STERLING RANCH RD & BRIARGATE PKWY.
SEGMENT 2 GESC

GRADING AND EROSION CONTROL PLAN
ADDENDUM

STERLING RANCH RD & BRIARGATE PKWY.
 SEGMENT 2 GESC
 GRADING AND EROSION CONTROL PLAN
 ADDENDUM
 DESIGNED BY MAW SCALE DATE 4/29/24
 DRAWN BY MAW (H) 1" = 100' SHEET 4A OF 9
 CHECKED BY (V) 1" = N/A JOB NO. 1183.30

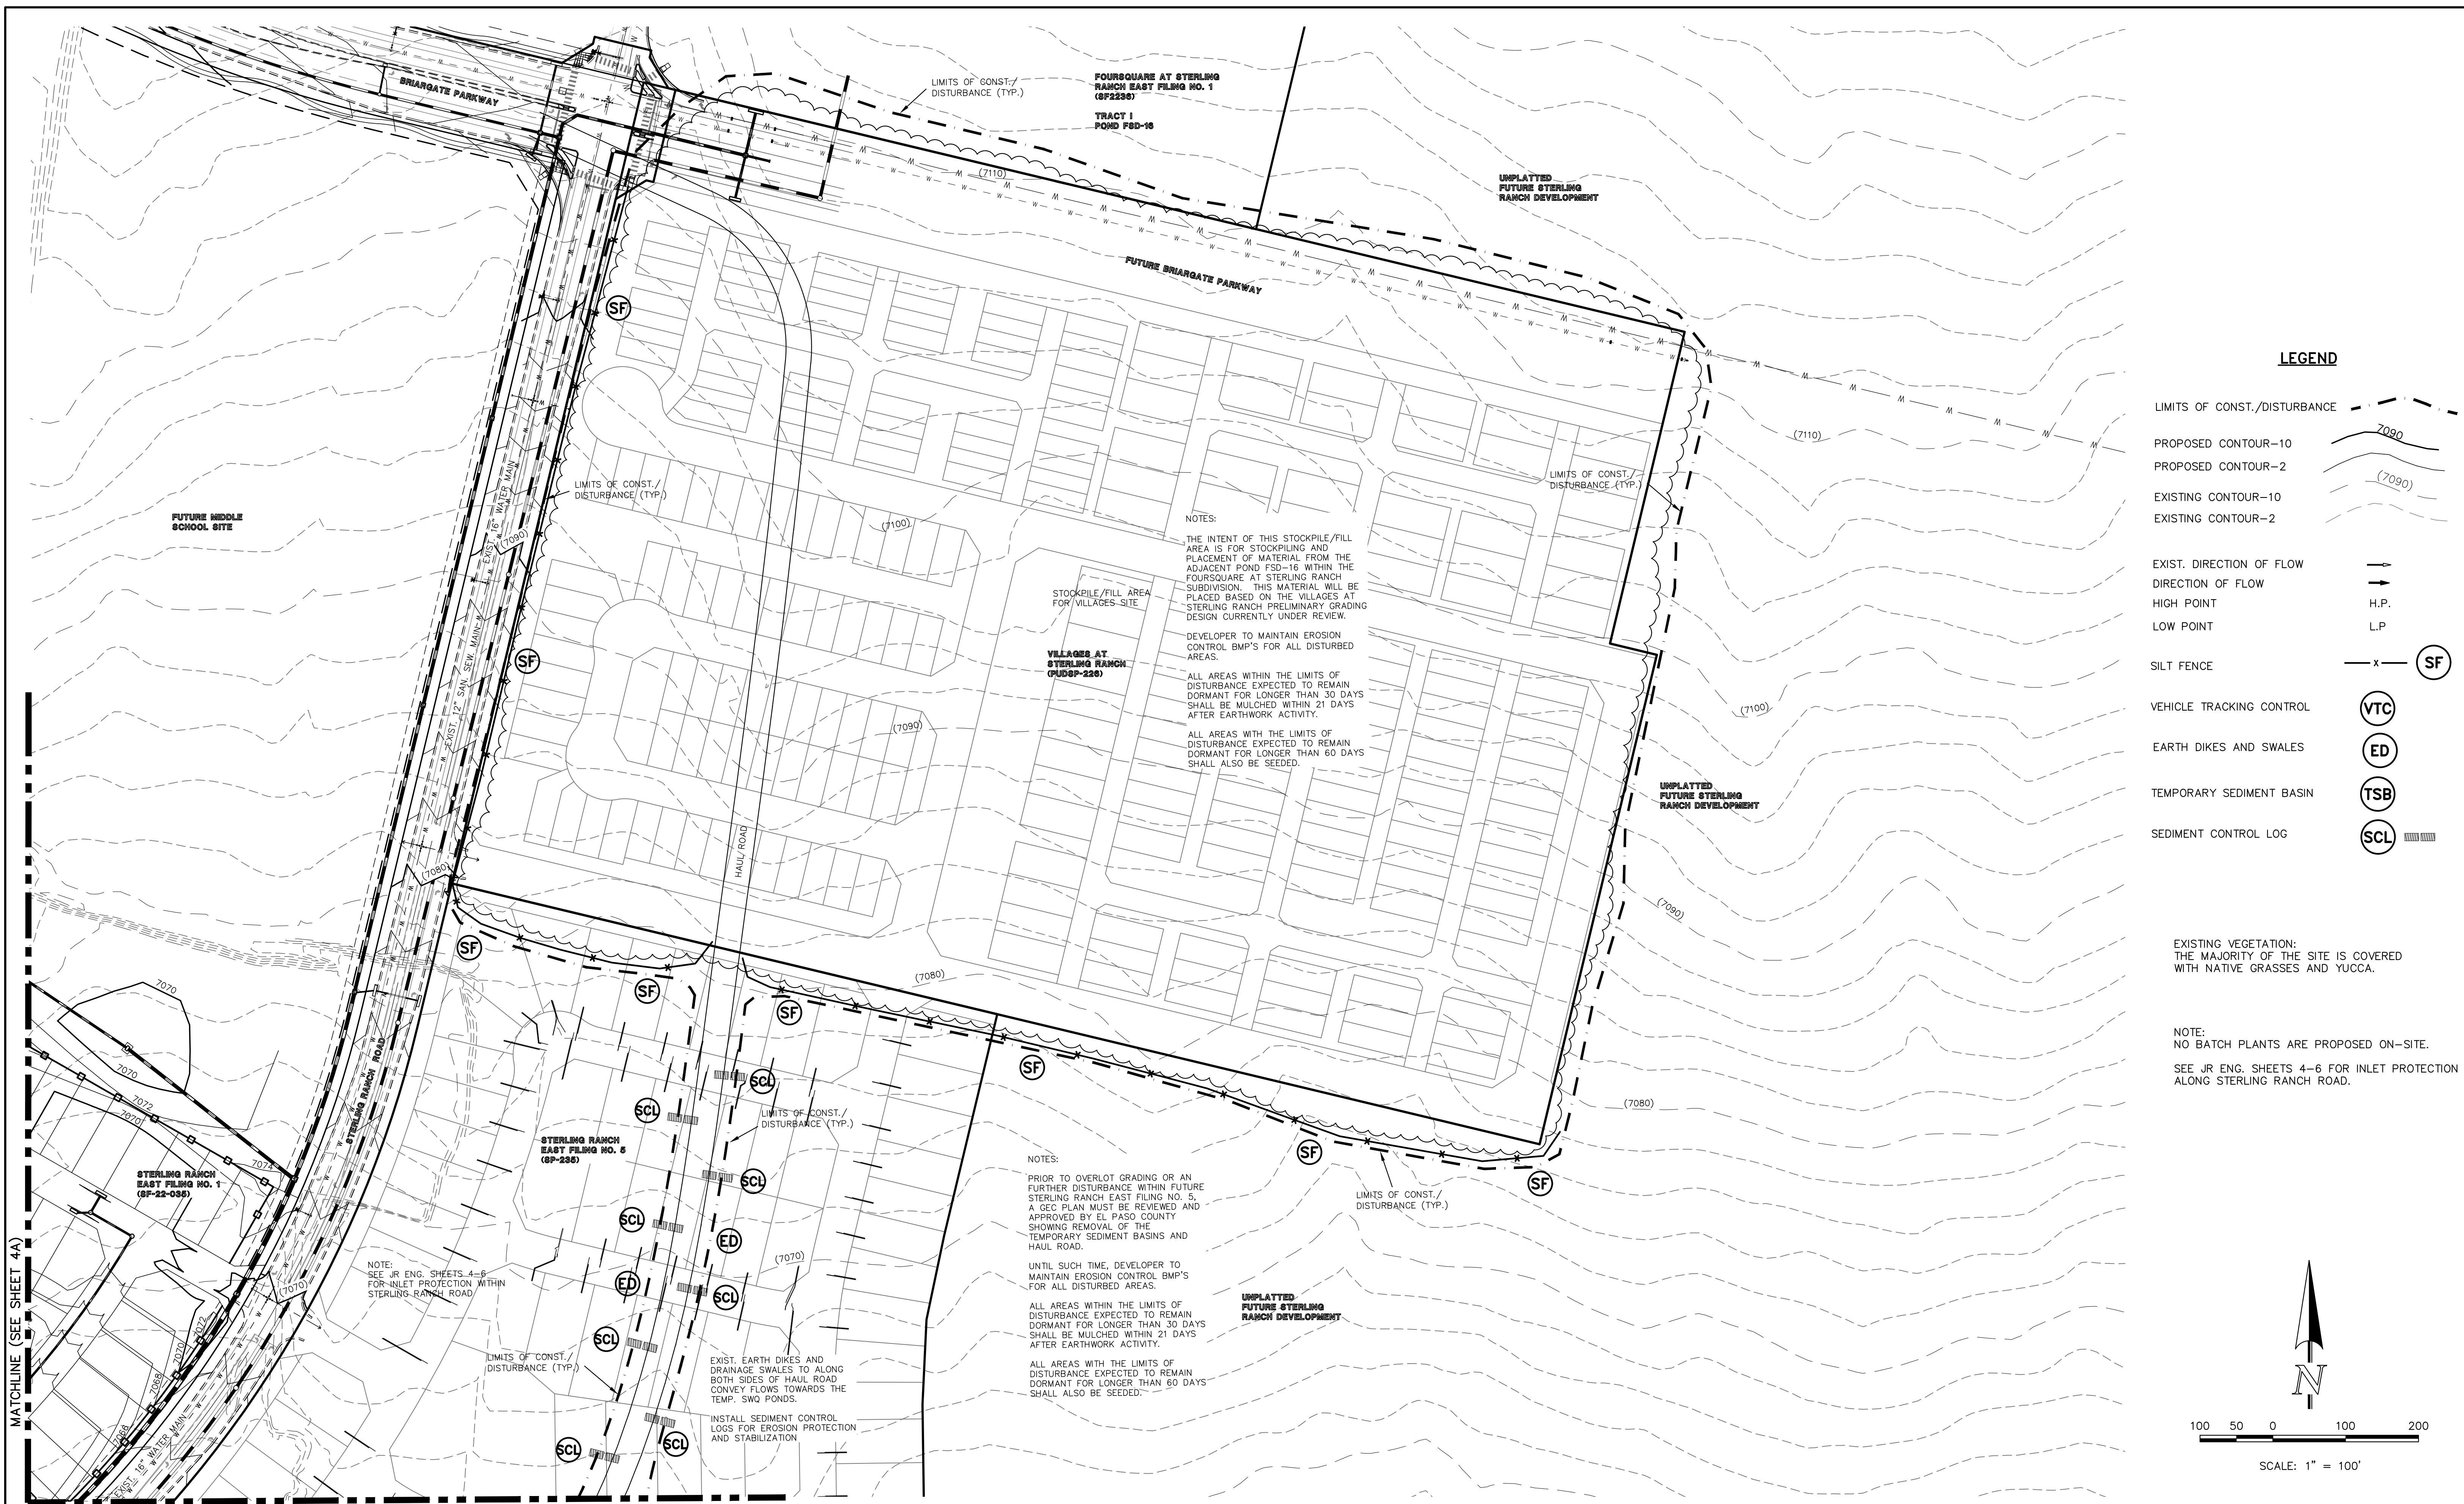
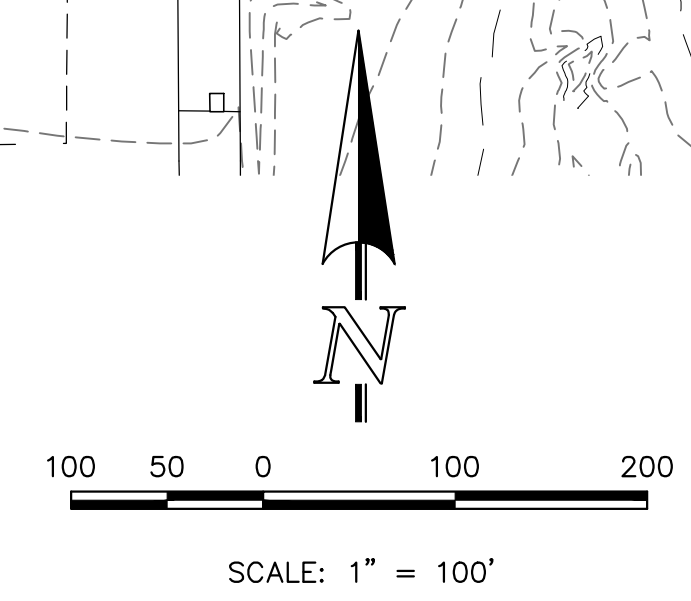
Provide details of temporary sediment basin including riser pipe diameter and perforation sizing, number of rows of holes, required volume, location of outlet pipe and spillway, and tributary area to the sediment basin. And provide contours for sediment basin.

Show proposed diversion ditches/swales to convey runoff to and from TSB.

DESIGNED BY	MAW	SCALE	DATE	4/29/24
DRAWN BY	MAW	(H) 1" = 100'	SHEET	4A OF 9
CHECKED BY	(V) 1" = N/A	JOB NO.	1183.30

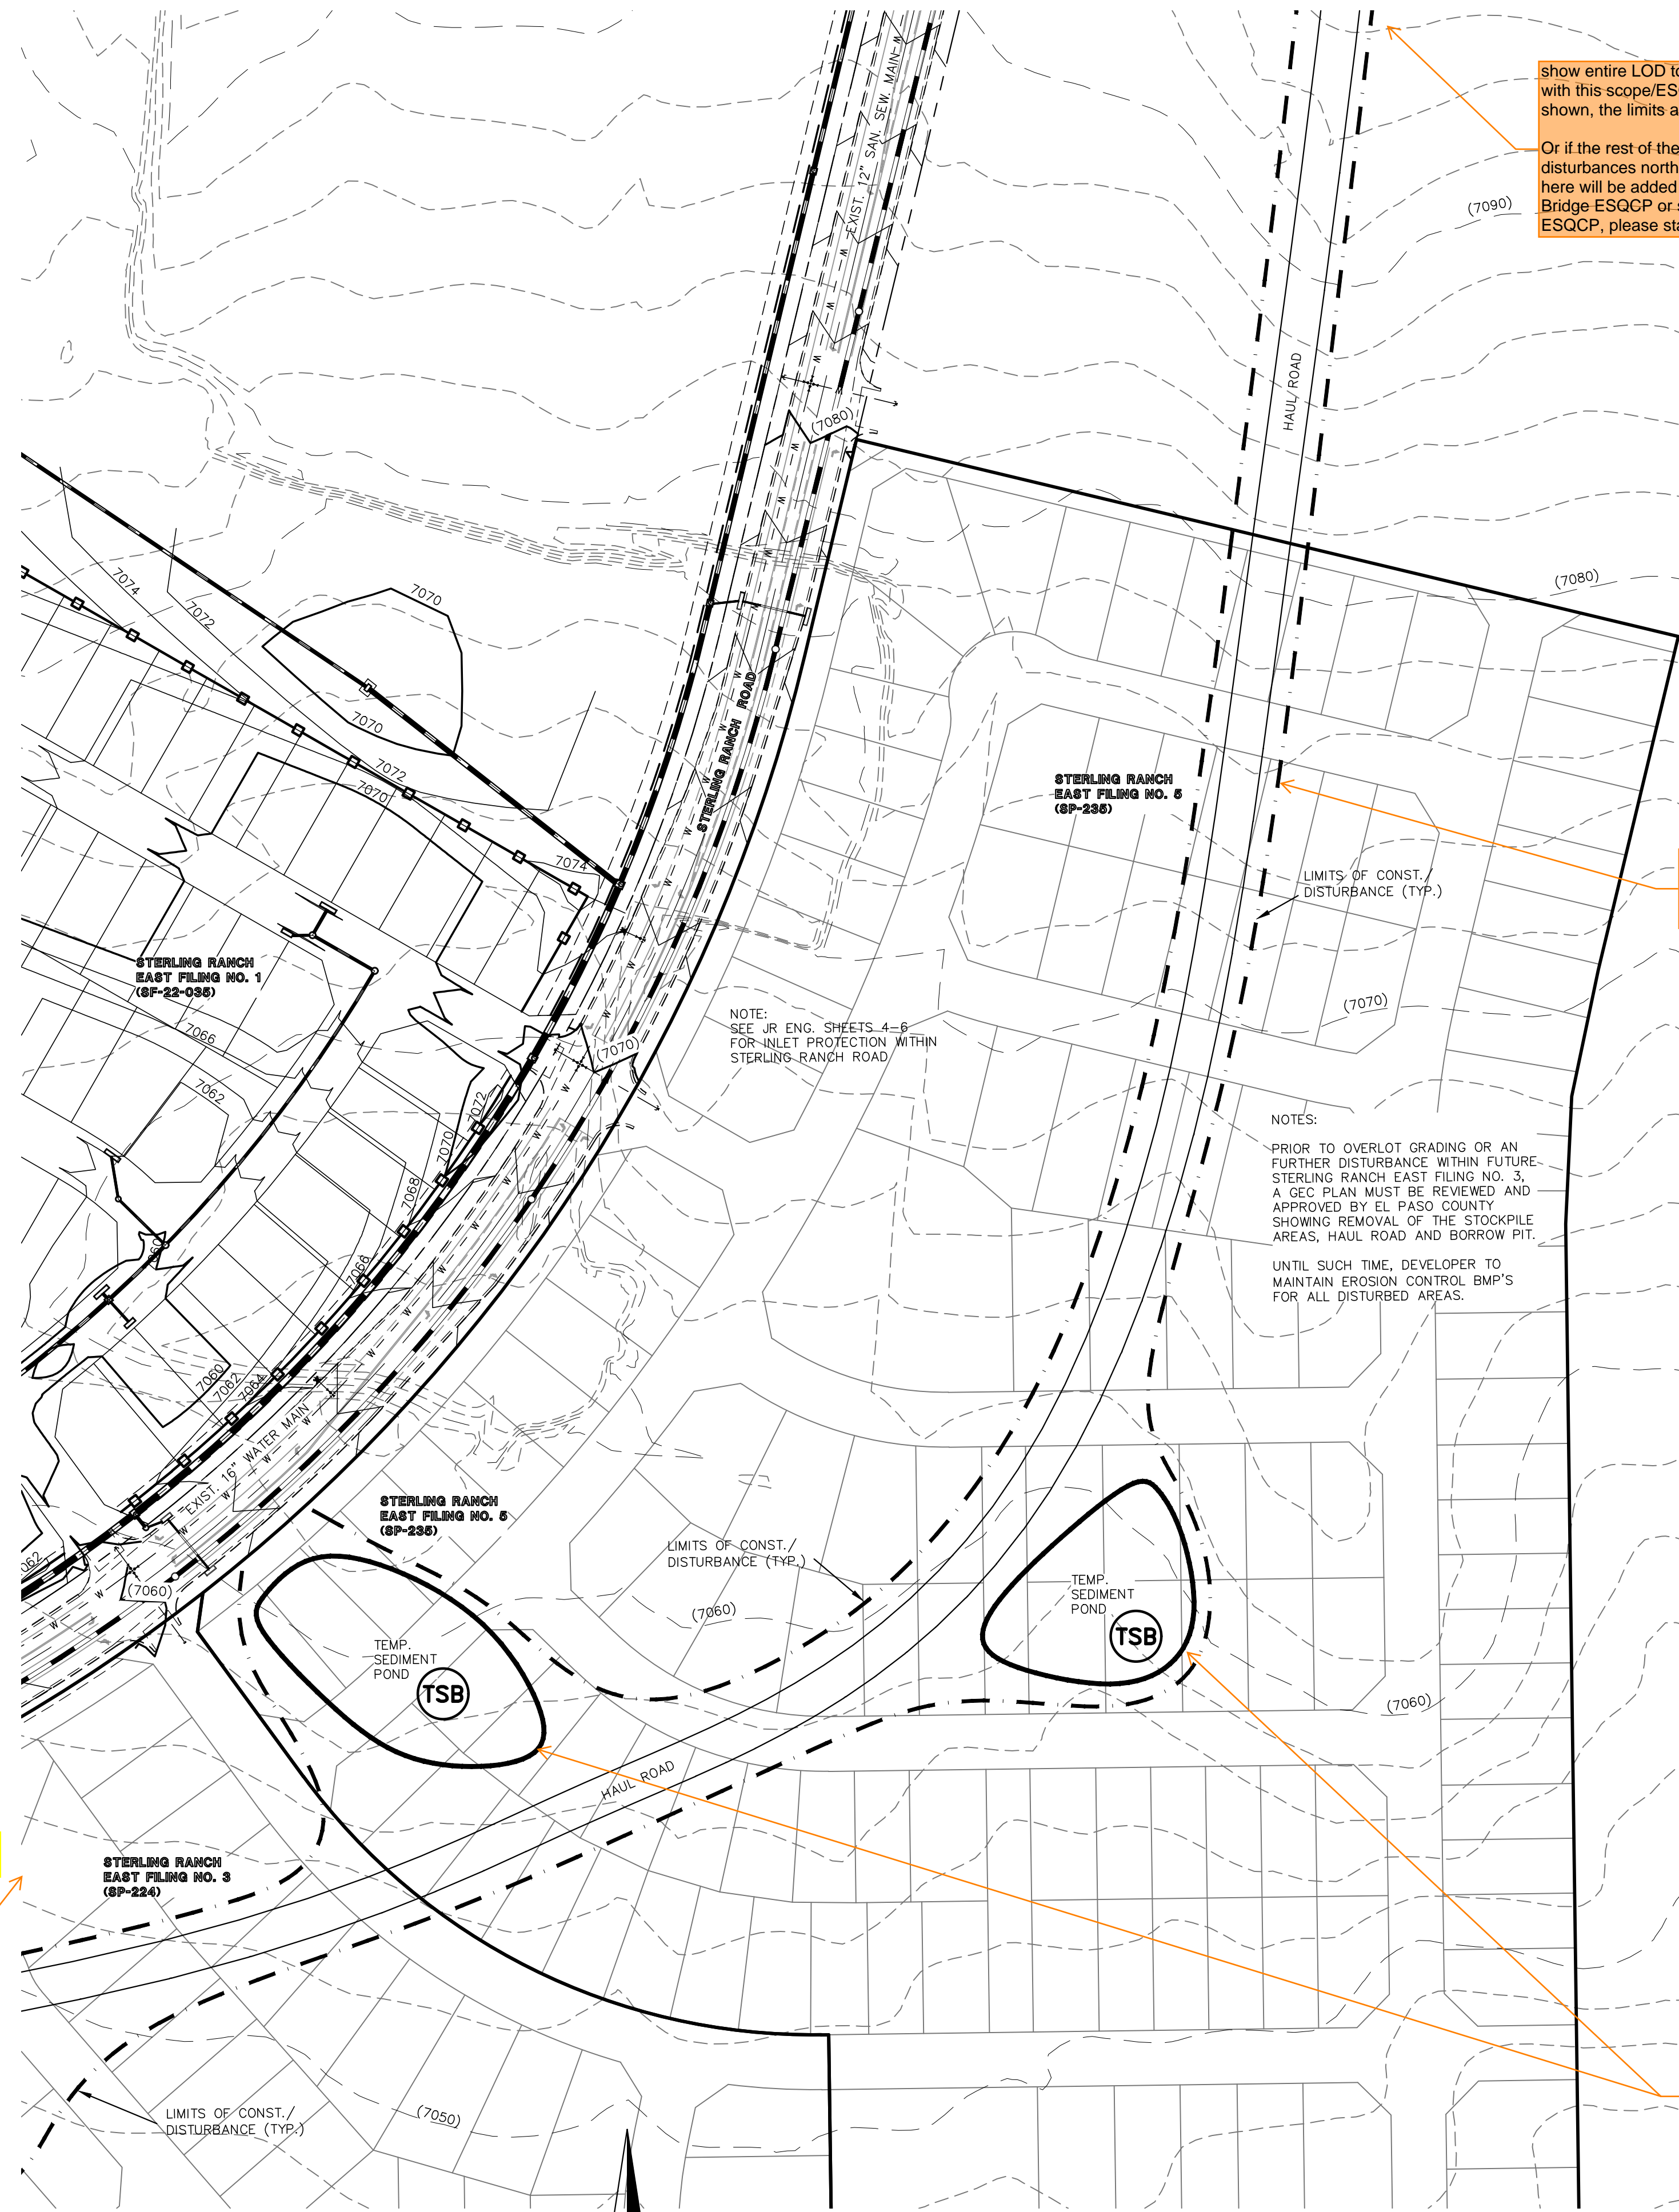
Seeding: Revise plans according to DCMv2 - Section 3.2 -
General Principles - Basic Grading, Erosion and Stormwater
Quality Requirements and General Prohibitions #16:

For any of the areas within the LOD on either sheet that are
not actively being graded, please show (or notate) areas to be
seeded and this note about timing.

Add a general note: all areas to be
vegetated with seeding should also be
temporarily stabilized within 14 days of
inactivity via surface roughening or some
other means.

show entire LOD to be included with this scope/ESQCP. As shown, the limits are cutoff.
Or if the rest of the unpermitted disturbances north and west of here will be added to the Briargate Bridge ESQCP or some other ESQCP, please state that here.

Consider need for a swale or berm along the road to convey flows to TSB.

See comment on previous page regarding TSBs.
Also, runoff tributary to these TSBs previously sheet-flowed across the surrounding land. Now the TSBs will discharge these flows as a concentrated flows. Please address this by providing a suitable outfall (riprap apron, flow path via swale) and/or some form of level spreader.
